SUTTON ST EDMUND PARISH COUNCIL

RE: Planning Application: H19-0329-24

Sutton St Edmund Parish wish to object to Planning Application H19-0329-24 for the following reasons:

Drawing Title: ALC Grade

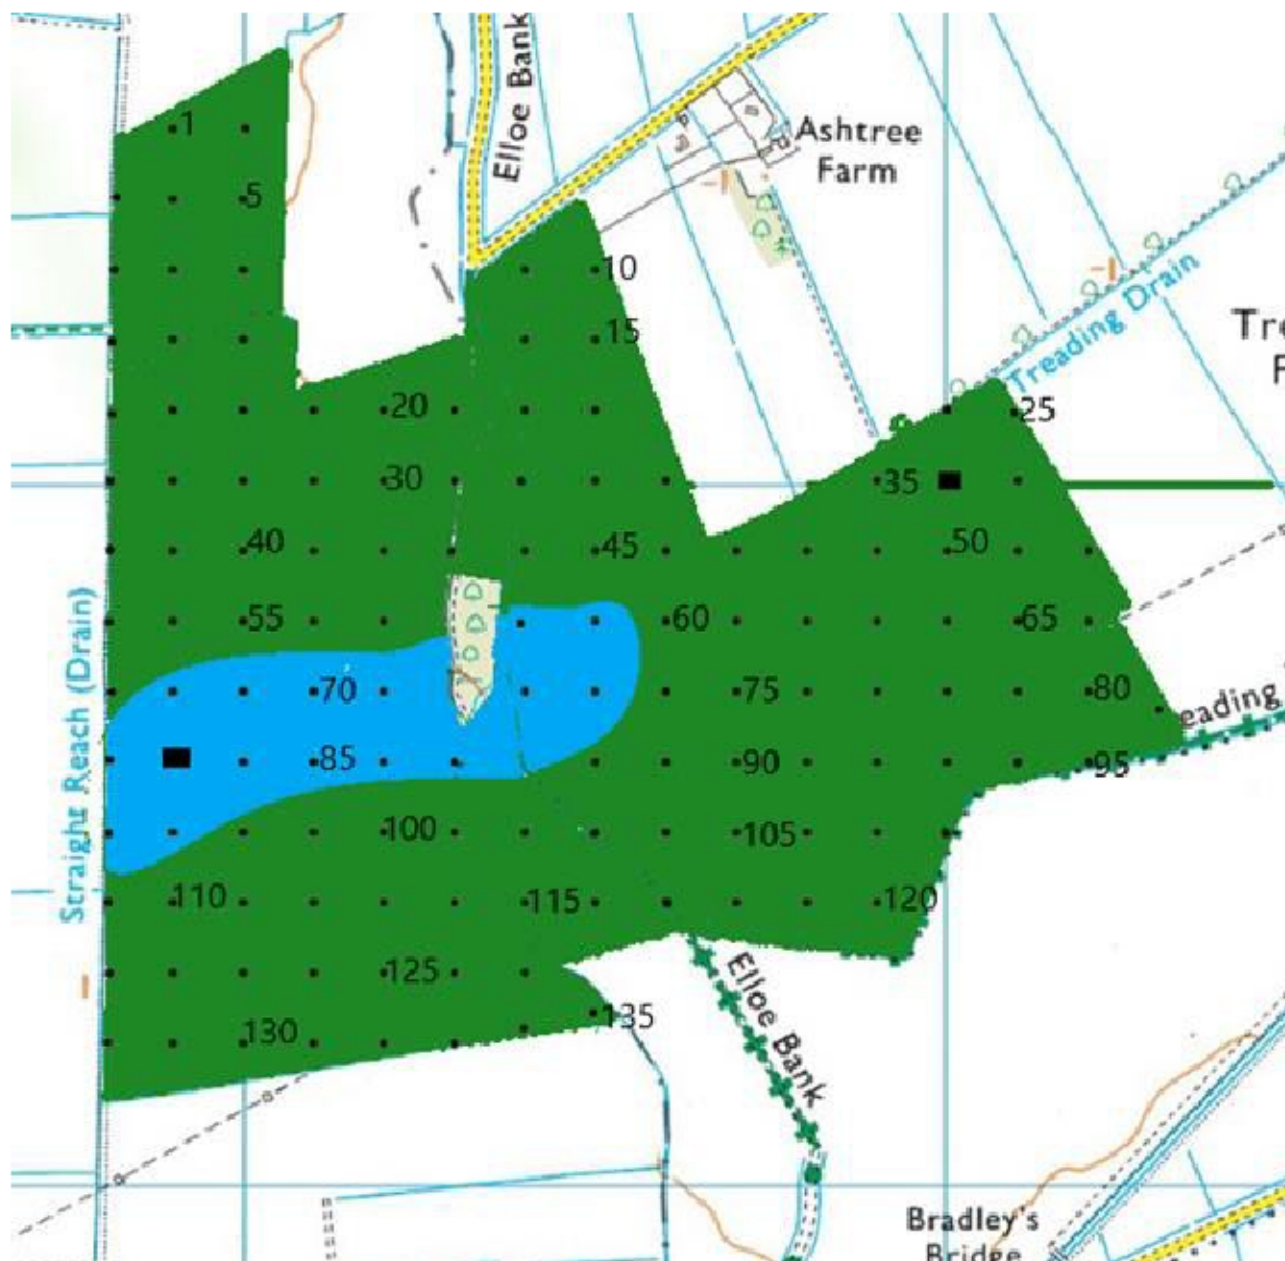
- The application is based on a soil test taken in June 2022, at this point in the crop growth cycle the soil is naturally depleted.
- Soil sampling can be affected by a number of factors including temperature, moisture, application, sampling depth. Nutrient levels in the field can vary due to a number of factors including local variation (distance as short as 1m), area variation, temporal variation. Given 2022 was a year of exceptional drought and samples were taken in June, the samples may not be representative of the correct grading.
